**Camden Council**

**RE: State Significant Development Application SSD 8378**

**PROPERTY: C The Hermitage Way, Gledswood Hills  
Lot: 3, DP: 1227491**

## Submission on Proposed Gledswood Hills Primary School – Key Issues

Figure 2 Extract of Building Height Plan (prepared by Perumal Pedavoli Architects)

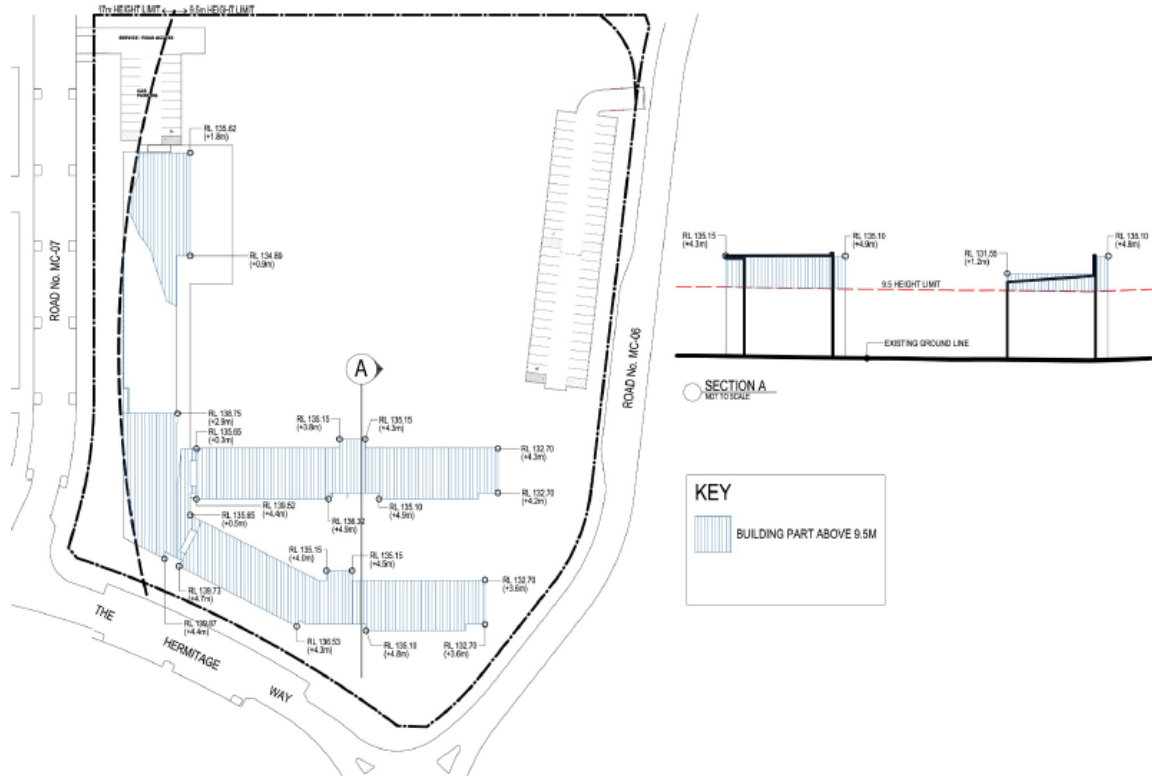
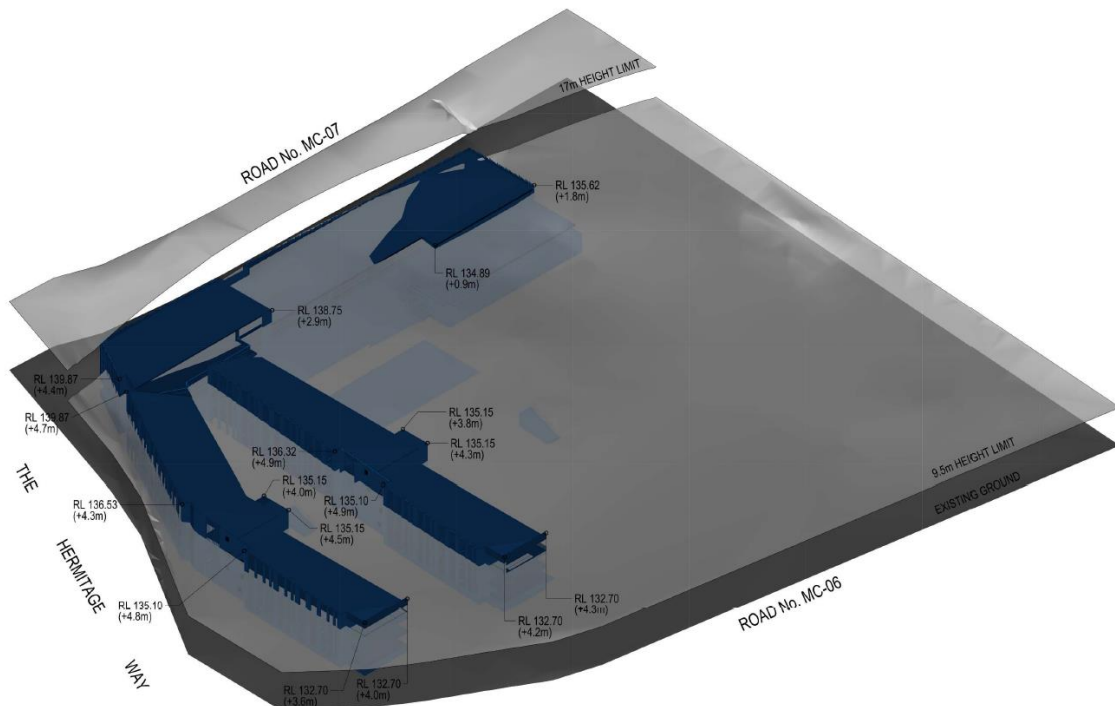
2. The maximum building height development standards for the site are 9.5m and 18m. The proposed development will have a maximum height of 14.4m. This represents a significant height variation of up to 4.9m (a 51.6% variation). The merits of this variation and its impacts upon the surrounding area must be carefully assessed by DPE.

3. All required roof mounted equipment should be integrated into the overall design of the proposed development to ensure it is neither visually dominant nor prominent. The proposed plans, including the assessment of the proposed maximum building height development standard variation, should reflect all roof mounted equipment that will ultimately be required.

**Figure 3 – Location of Bus Bay and Drop Off Zone**

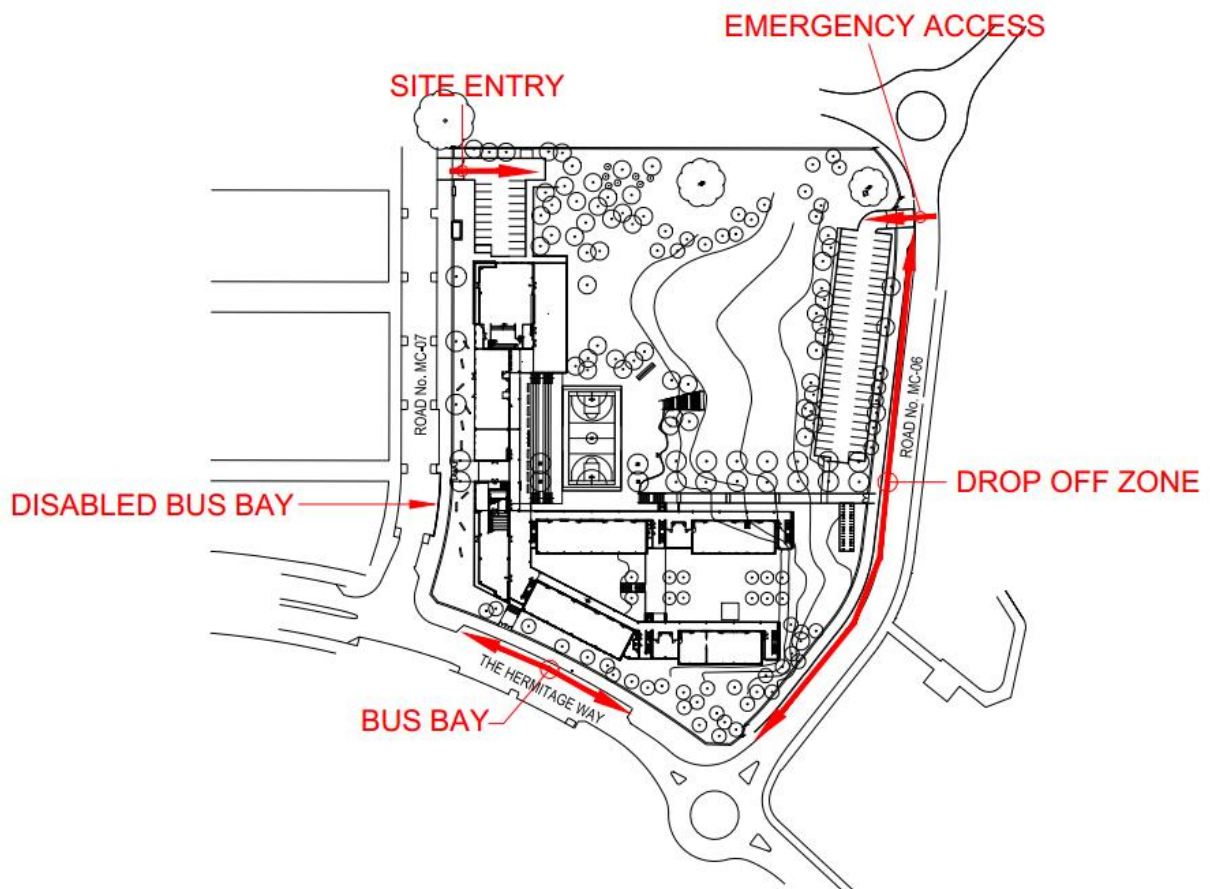
- The proposed accessible bus parking area on road MC-07 should be modified to be a general disabled car parking area that is available for both the accessible bus and disabled car parking. The accessible bus parking times should be staggered to ensure they do not conflict with general disabled parking for the school.

The special education components of the school should be located in close proximity to the accessible bus parking area.

2. The proposed development should provide capacity to accommodate five buses. This is in consideration of similarly sized schools in the Camden LGA and their bus accommodation capacity/needs. Reliance upon staggered bus arrivals is not supported as a means of addressing bus capacity issues

On-street bus bays must be designed in accordance with the applicable schools facilities standards.
